From: Roger Spencer
Sent: 07 March 2014 15:51
To: Planning.Responses
Subject: RE: Planning Consultation on: LU/29/14/

Site Address: Unit 1 Lineside Way Lineside Industrial Estate Littlehampton
BN17 7EH

Description of Works: Extension to existing steel framed purpose built industrial unit plus overclad existing brick & corrugated building with finishes to match new extension.

Title: Plans and Elevations
- Existing & Proposed

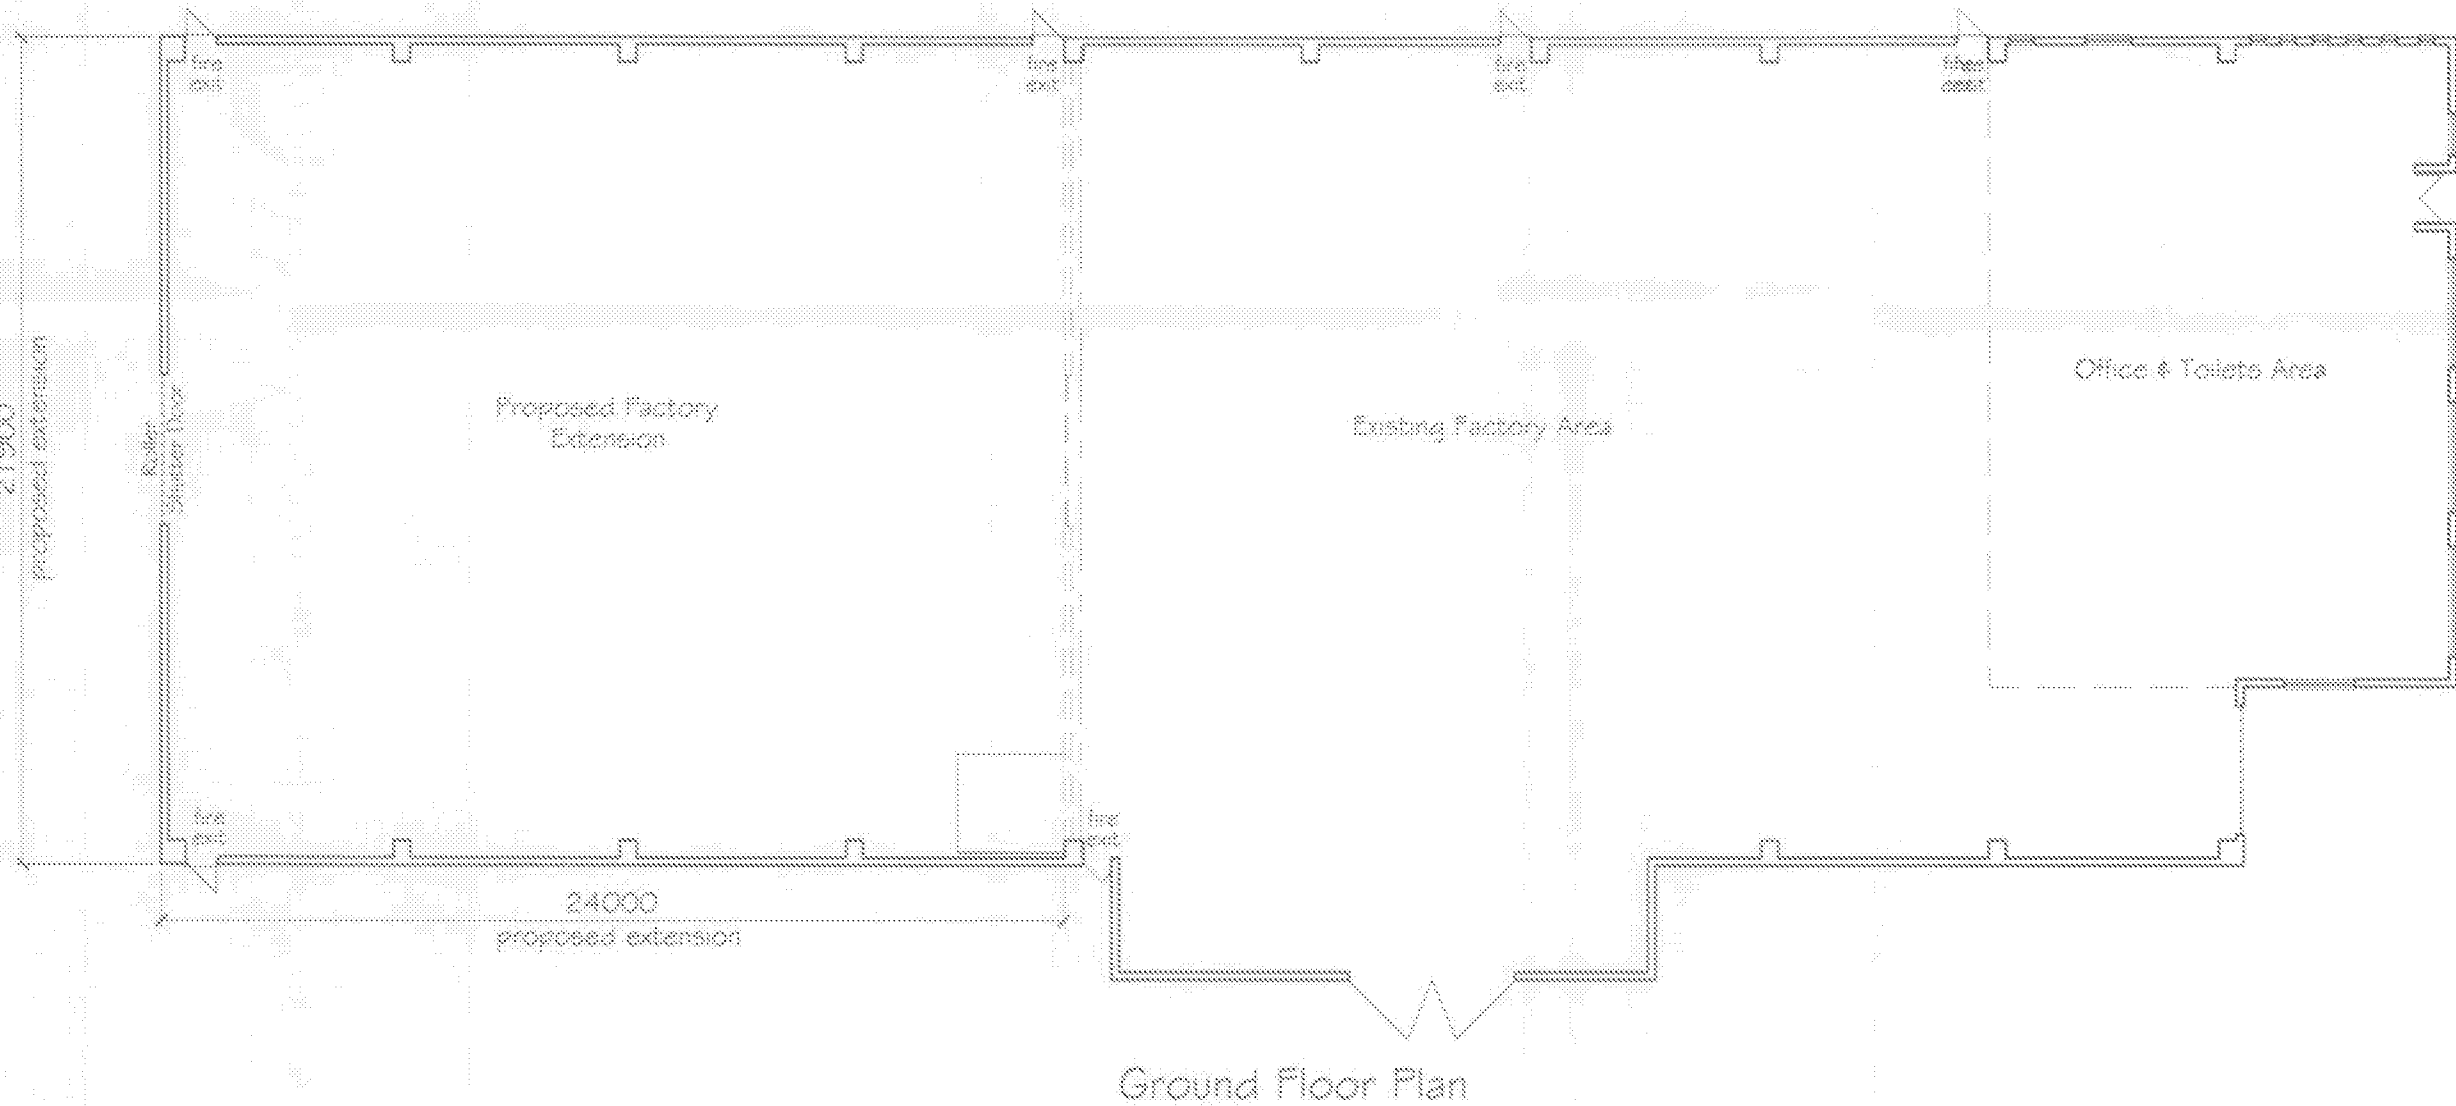
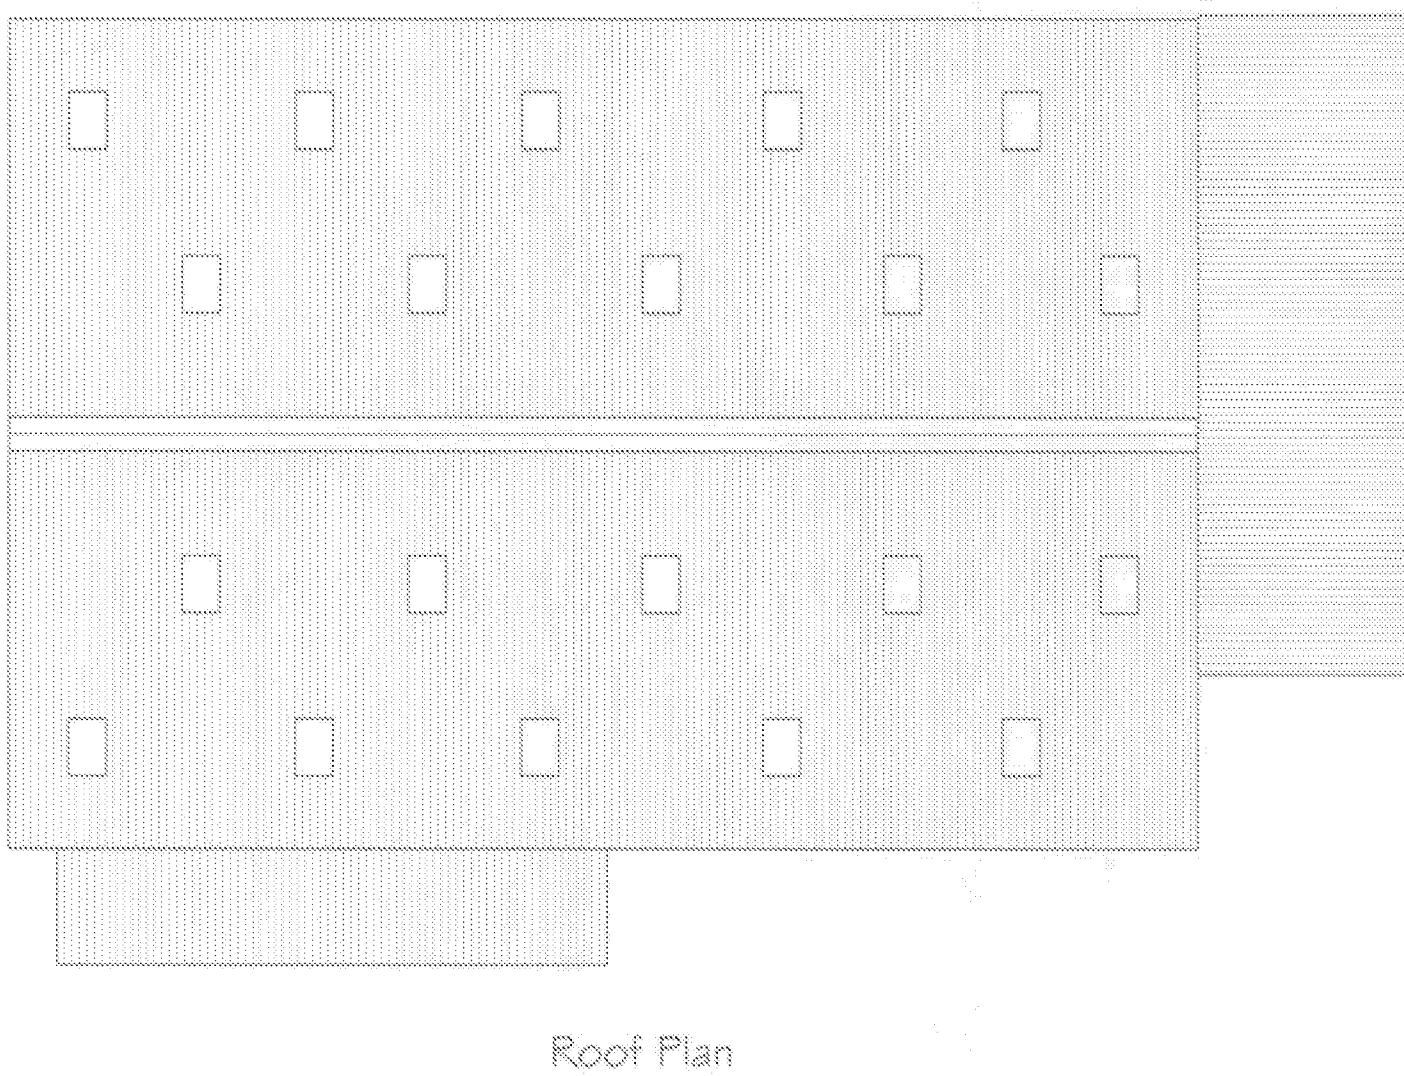
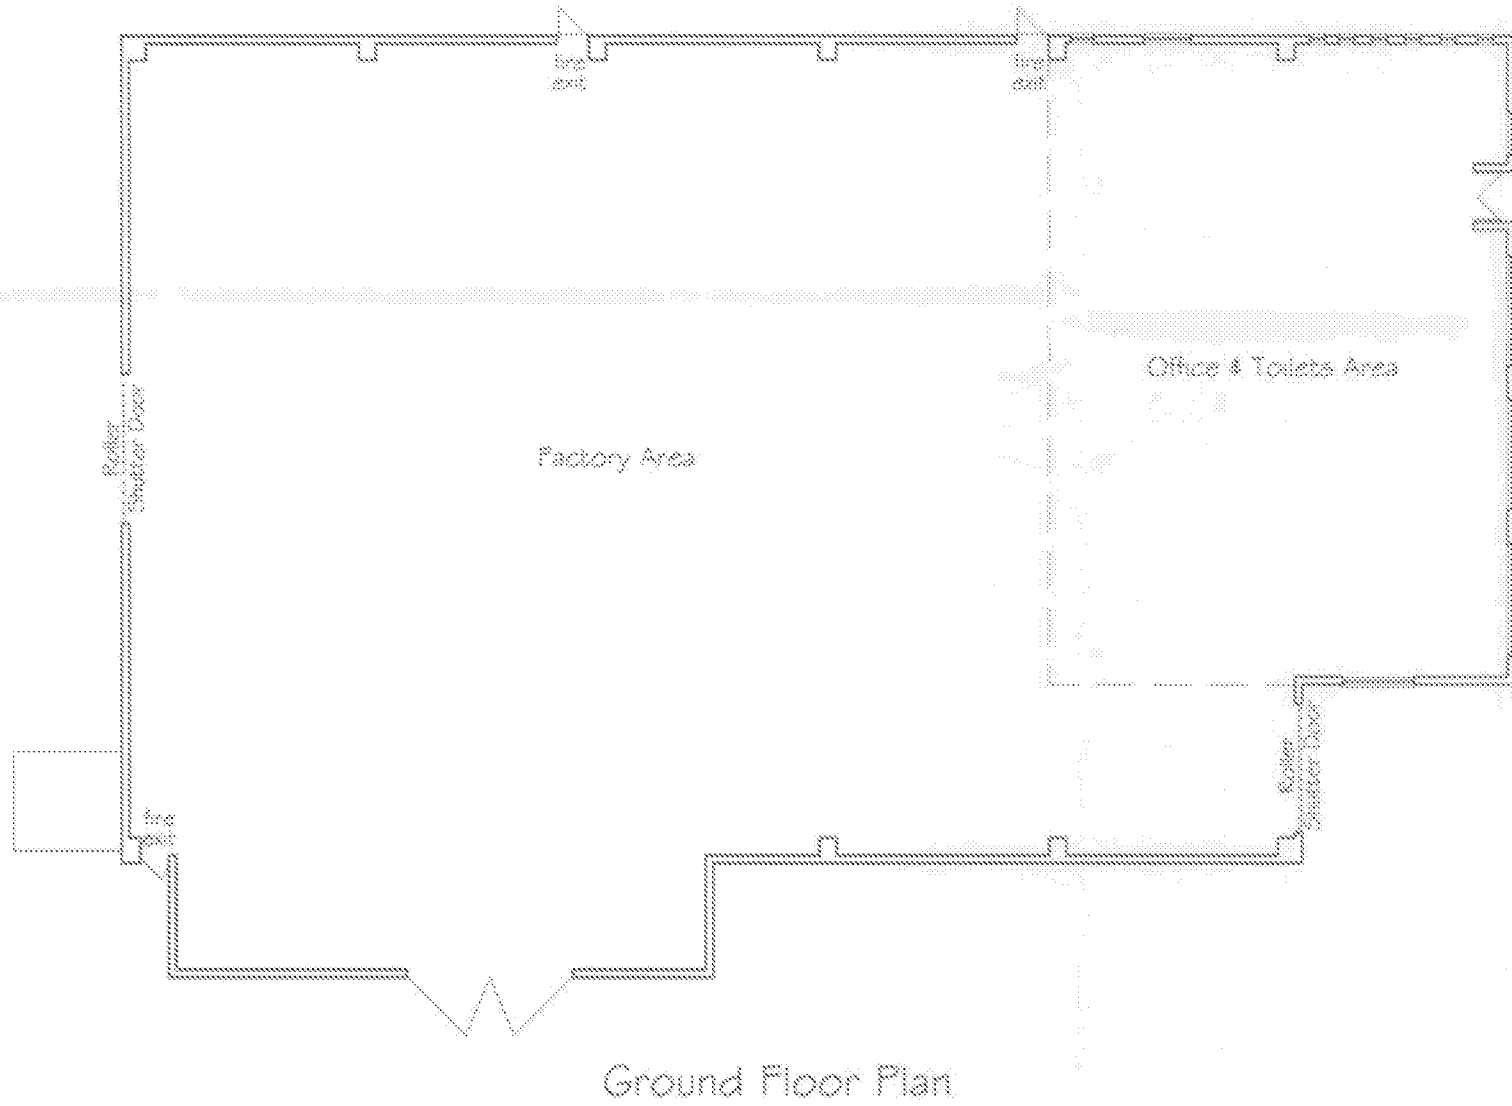
The development is within flood zones 2& 3 on the EA's Flood Map but the propagation route is from a section of the River which will soon be covered by the current East Bank Flood Defence Scheme.

Being an industrial development, there should be no residential element but you may wish to raise the fact that there is no flood risk assessment included with the Application -- or include an advisory to the applicant that the development may, for a short period until the defences are completed next year, be at flood risk.

Other than this, I have no comment on Coast Protection grounds but I am sure my drainage colleagues will want to mention the fact that the proposal seems to go over a Public Sewer.
